West Bradford Parish Council

Planning Application No: 3/2011/0533

Proposal: one detached dwelling to be built on a former car park

Location: land adjacent to 5, Hazeldene West Bradford Lancashire BB7 4TD

4123 - 03c

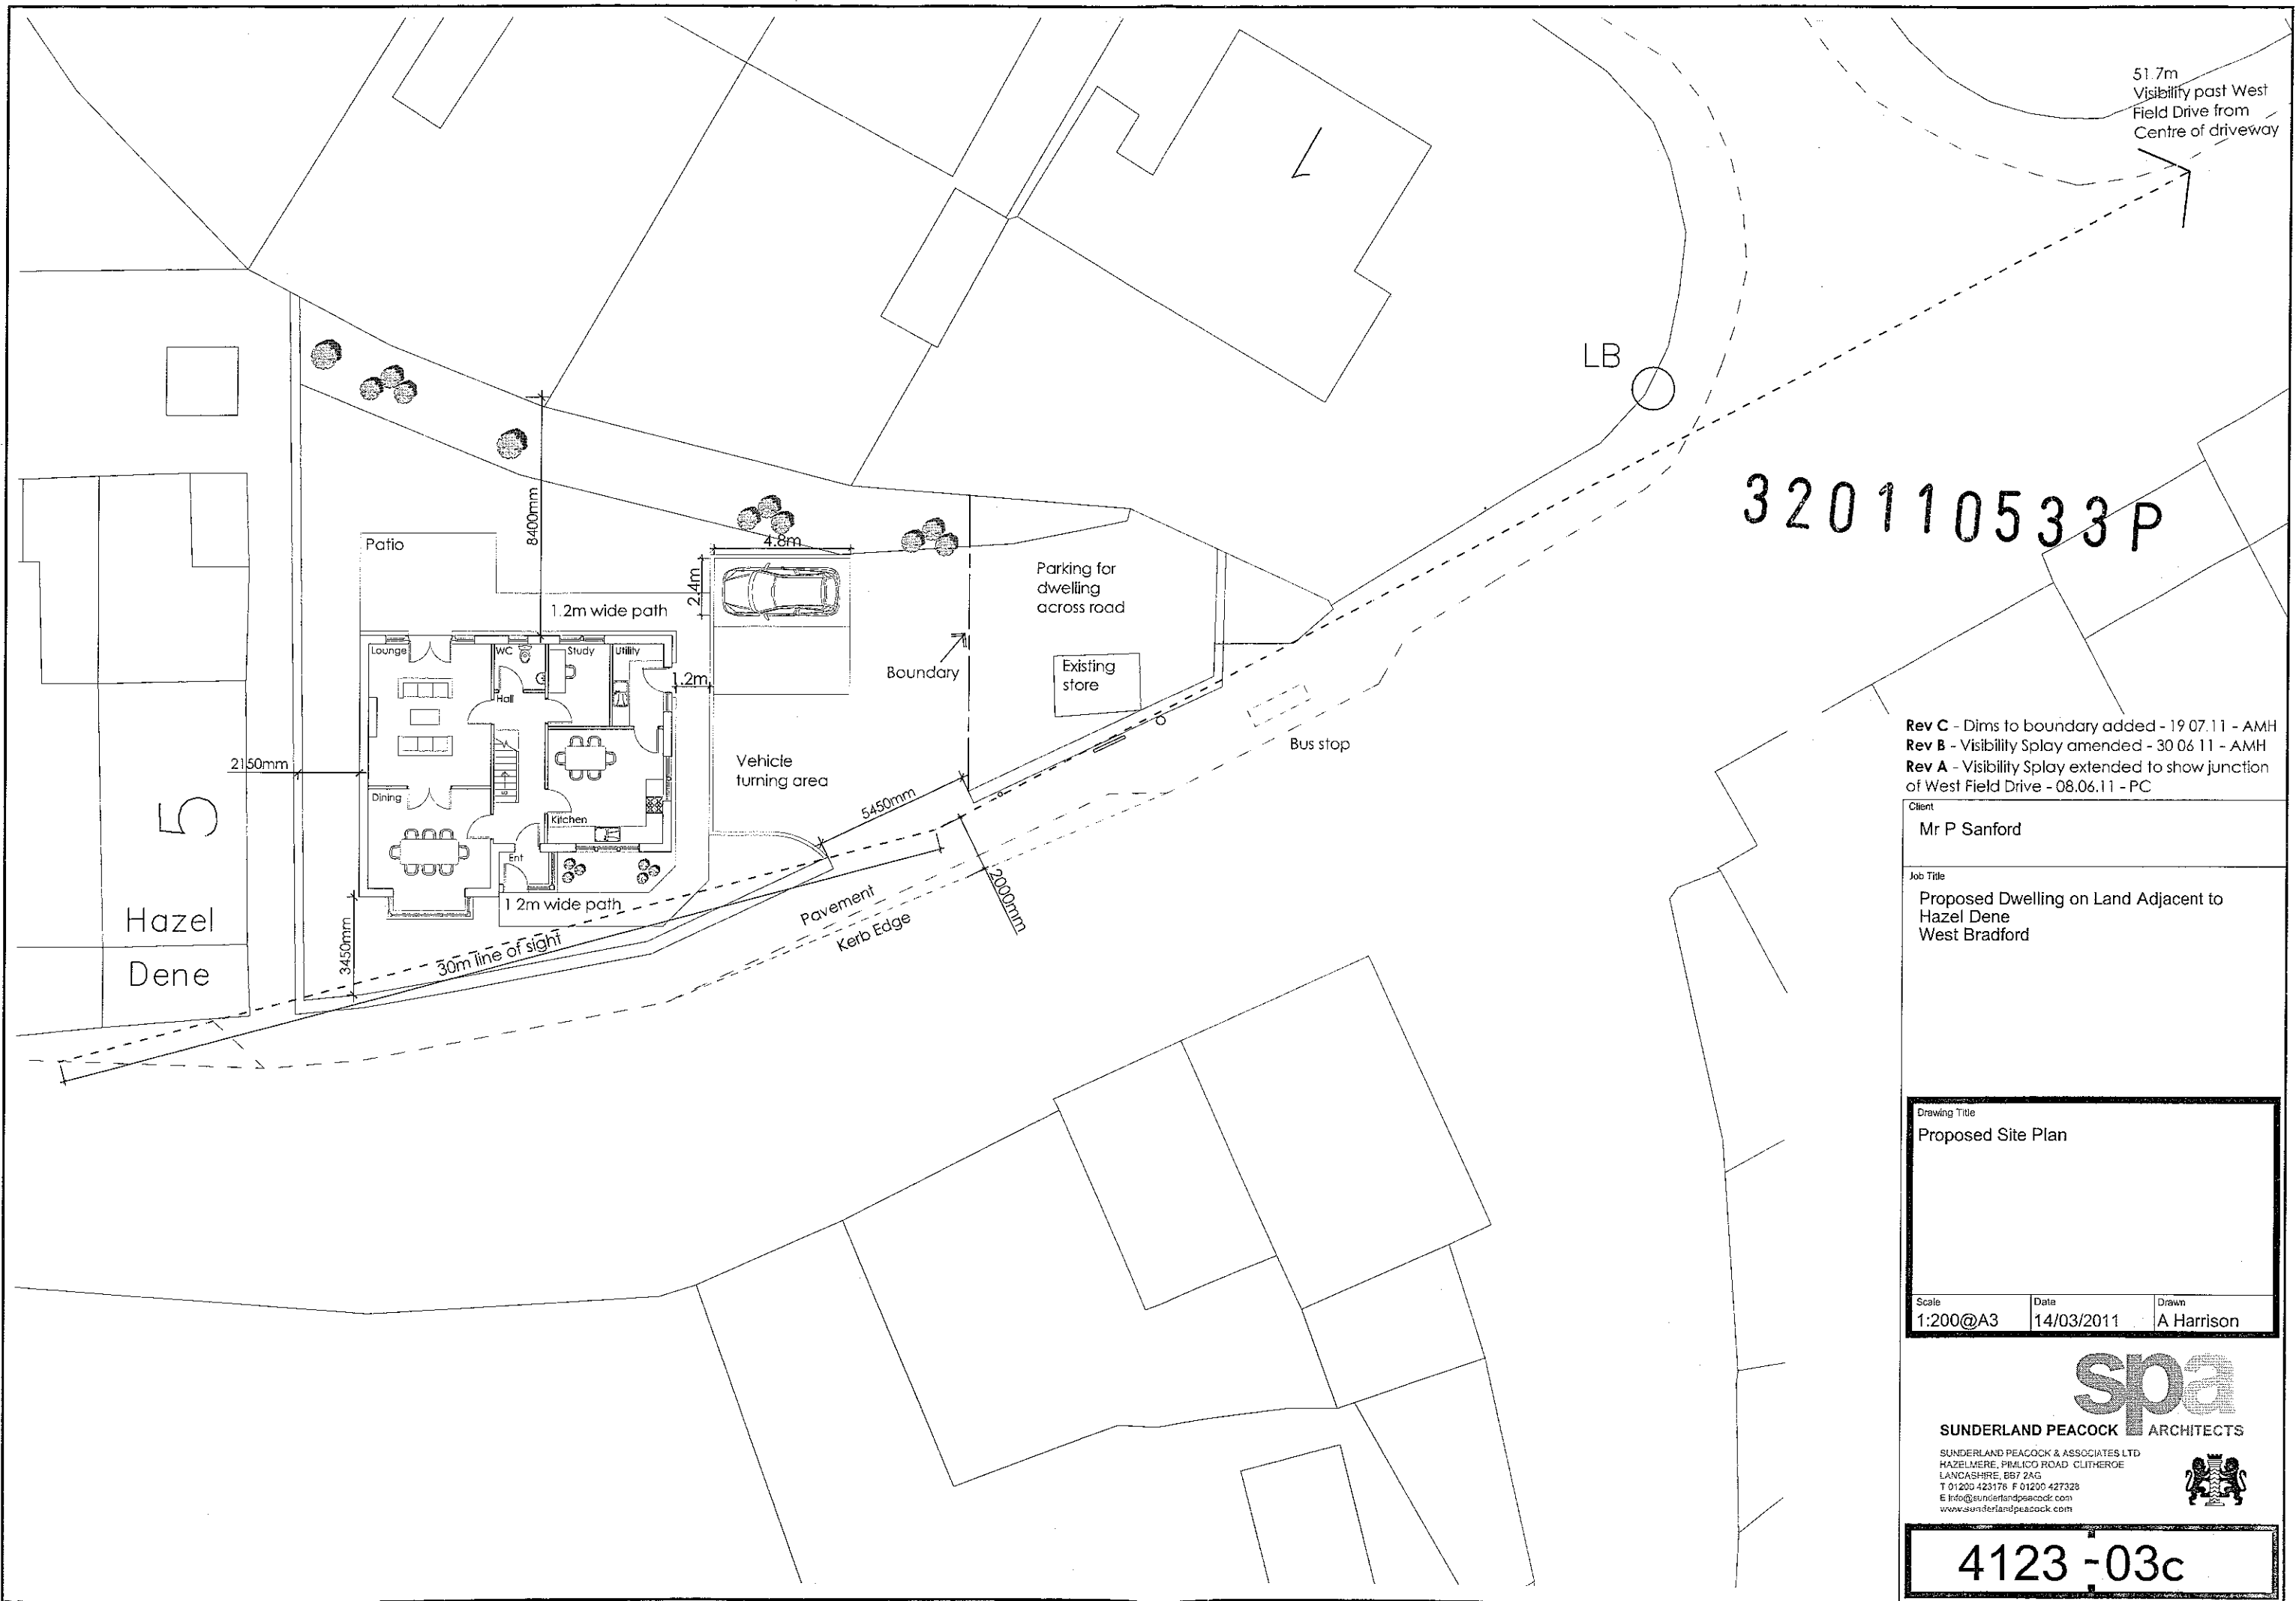
Another problem is the properties of 3, and 5, Westfield Drive being overlooked, a recent application in West Bradford was turned down and one of the reasons given was loss of residential amenity by virtue of overlooking and the resultant loss of privacy to the residents contrary to the policies G1 and H10 this refusal was also upheld following an appeal. In 2011 a revised application was submitted and again was refused on similar grounds.

- 1, Overloading of the surface and foul water drains.
- 2 Loss of residential amenity to 3, and 5, Westfield Drive
